ADL Traffic and Highways Engineering Ltd

Our ref: ADL/RG/Is/2680

3 March 2020

Re: A38 DERBY JUNCTIONS PROJECT: DEADLINE 6

Drawing Title  
FIGURE 2.6  
MARKEATON JUNCTION  
GENERAL ARRANGEMENT

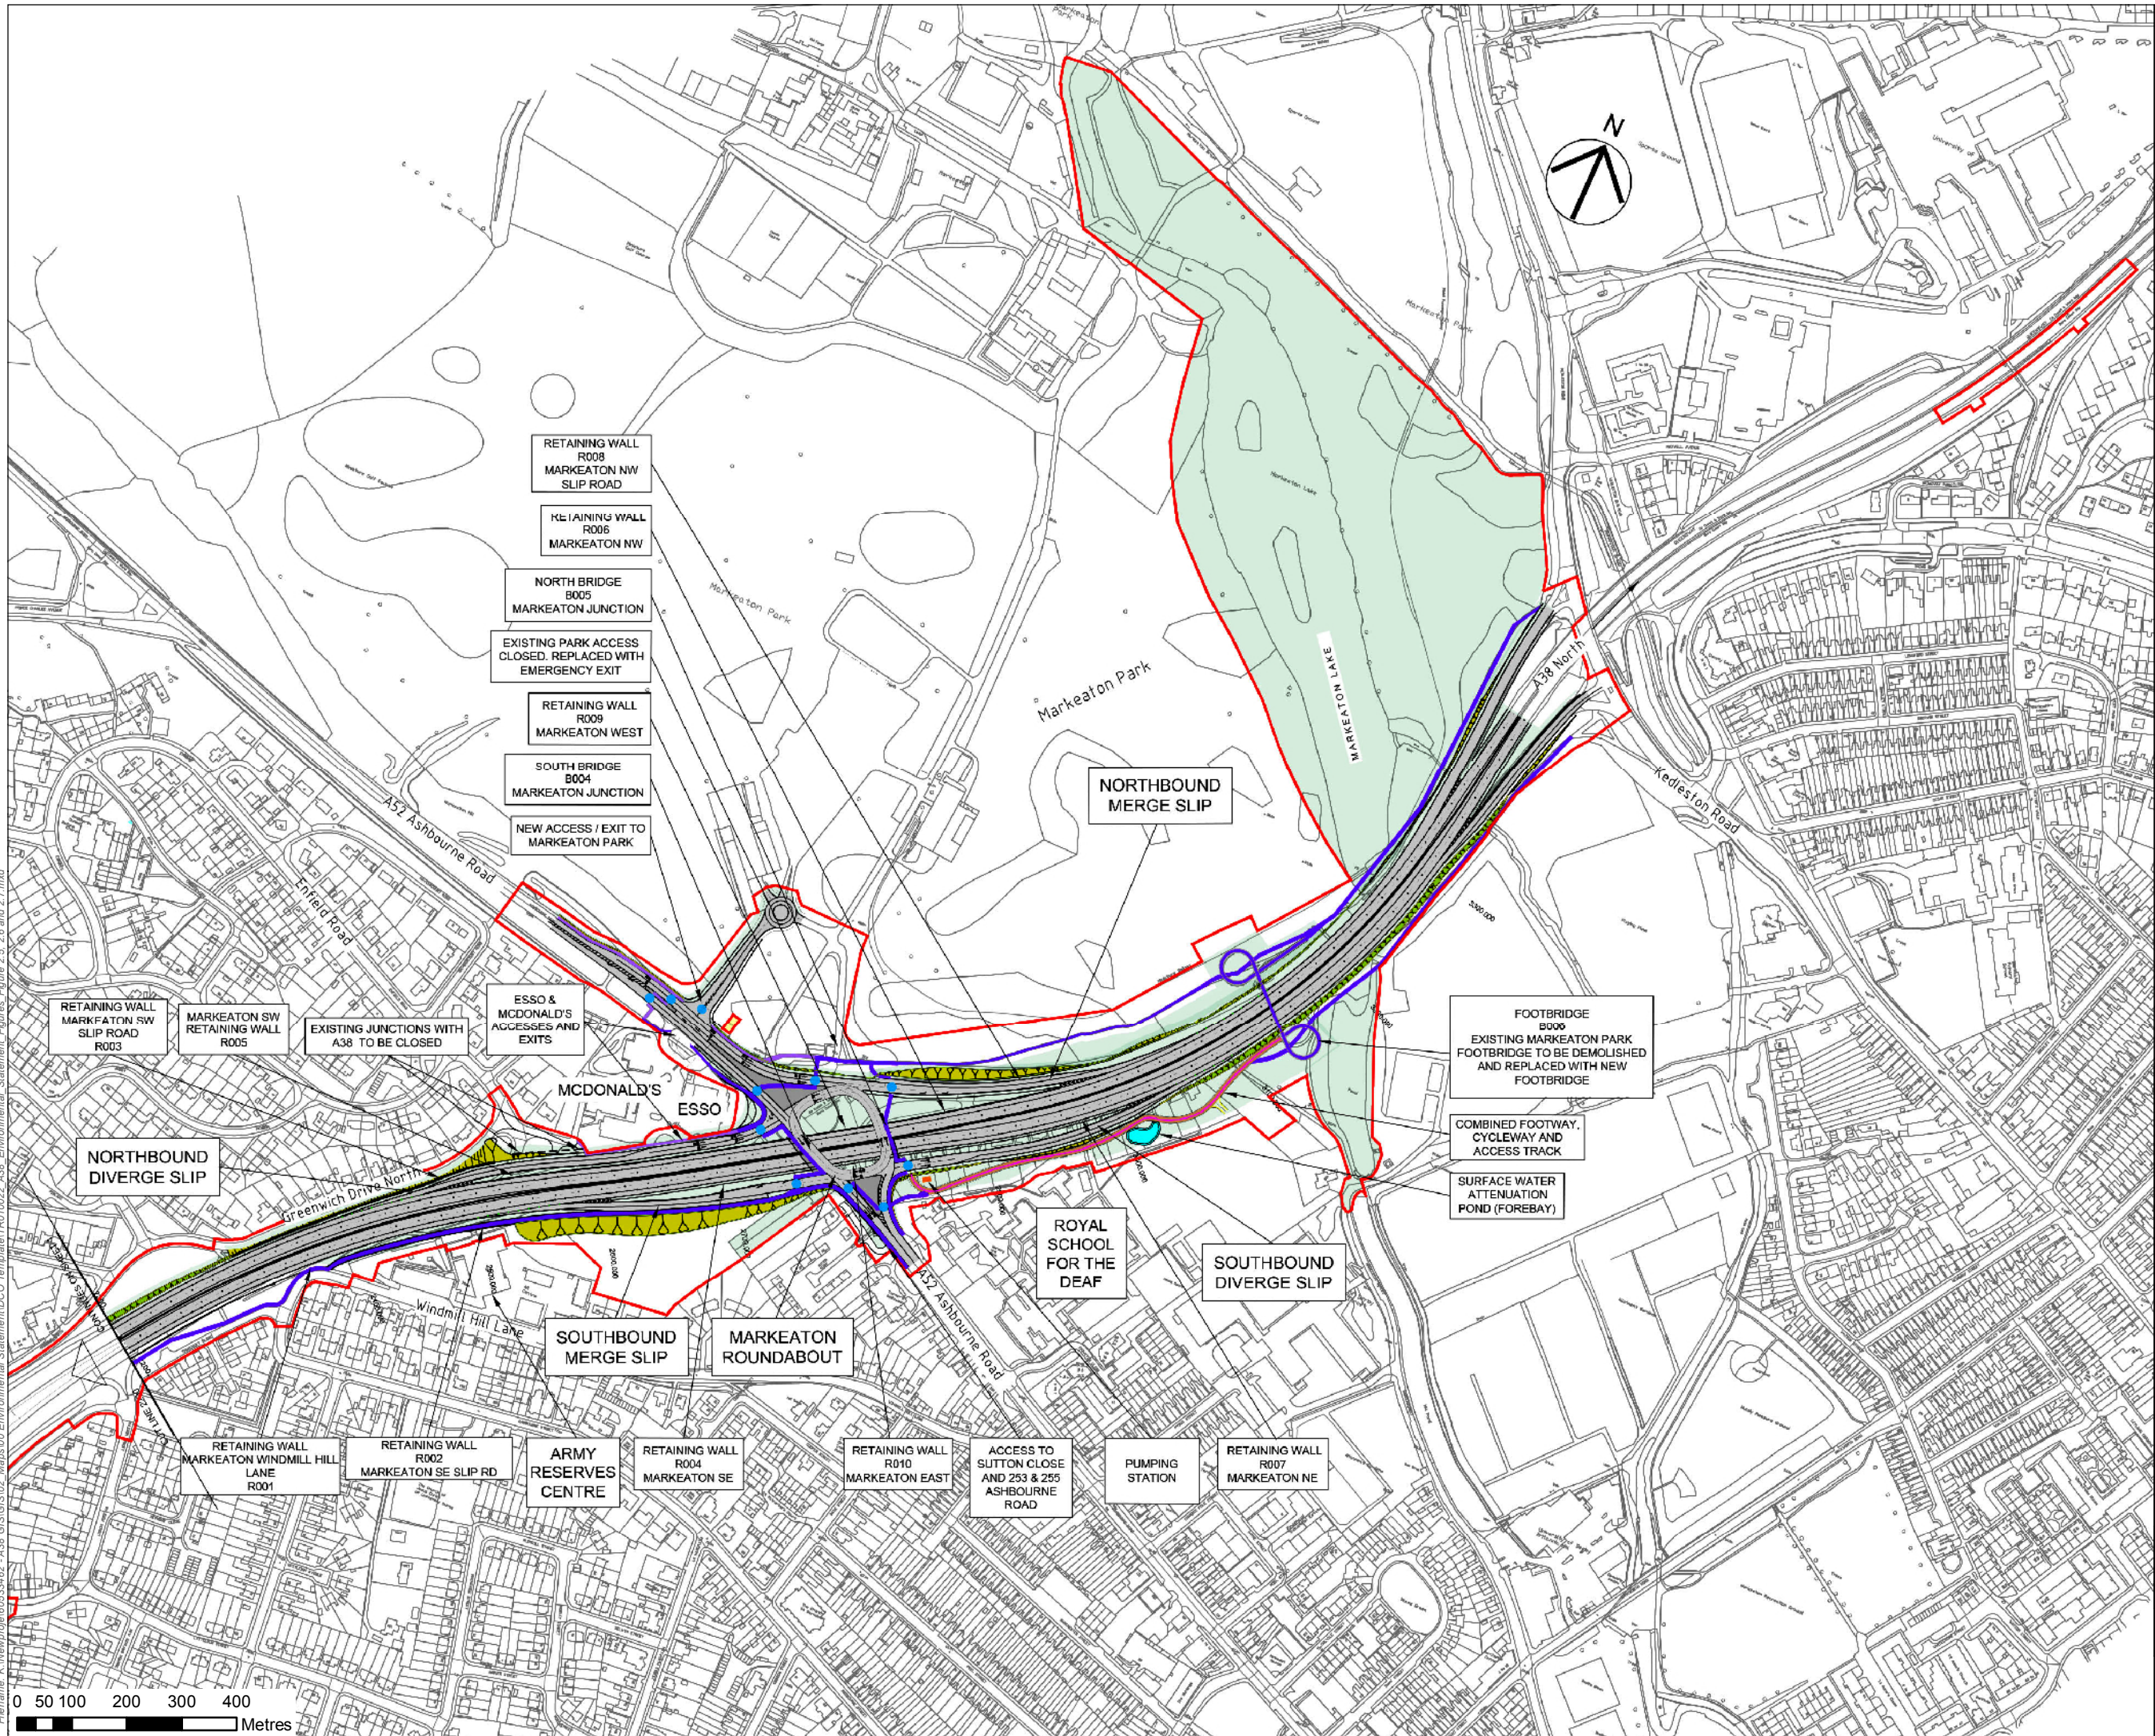
The left turn in from the A52 remains a tight manoeuvre (particularly for HGVs) and there does not appear to be scope to improve on this, given the constraints of the available highway land, McDonald's land and Eurogarages land.

Considering these entering vehicles; drivers unfamiliar with the site, including HGVs seeking to refuel at the garage have limited time to slow to a speed appropriate to undertake a full u-turn manoeuvre into the site. Whilst car drivers will find the manoeuvre into the wider site easier, they will still need to reduce speed considerably, then have to make a decision about making the right turn into the McDonald's car park, or continuing to the PFS within around two car lengths, whilst making a judgement about gaps in oncoming traffic leaving the PFS.

Turning to exiting traffic and referring again to attached drawing 2680-SK-22, these constraints are highlighted once more, as it would only take a queue of seven vehicles back from the stop line, before blocking the approach to the drive thru lane entrance, and eight, before the drive thru lane exit would be blocked.

Based on HE's own traffic flow data, closure of the access from the A38 would involve directing approximately 100 vehicles per hour who would visit McDonald's or Eurogarages, from the A38 south approach, through the proposed gyratory and require them to use the signalised access into the wider site from the A52 to make the u-turn in. These 100 vehicles making the turn in would be part of an hourly flow of over 1000 vehicles heading to the A52 westbound through the junction. It would seem that HE's concerns under the CDM regulations 2015 with regard to the designer's duty

...do not extend to the risks associated with introducing 100 u-turn movements per hour to the proposed traffic signal junction, which could otherwise be avoided, by maintaining access from the A38. Whilst HE's own team may foresee health and safety risks associated with maintaining access and egress from the A38, they have failed to acknowledge the wider implications and the potential risks associated with introducing a high number of u-turns off of the A52 into the site.

"The proposed access into the new Esso/McDonalds access appears tight. If vehicles cannot safely turn into the access from Markeaton roundabout kerb strikes may occur or grazing collisions with vehicles waiting to turn right out of the junction onto the A52."

Therefore, the risks associated with an access which "appears tight" and requires a u-turn manoeuvre, on a road with a flow of over 1000 through vehicles per hour, do not appear to have been considered in the context of those same 100 vehicles making a less tight left turn in from the A38, as part of a passing flow of fewer than 500 vehicles in either peak hour. We require further explanation of how one option is considered to eliminate "foreseeable health and safety risks" over another, given the manoeuvres and traffic flows involved.
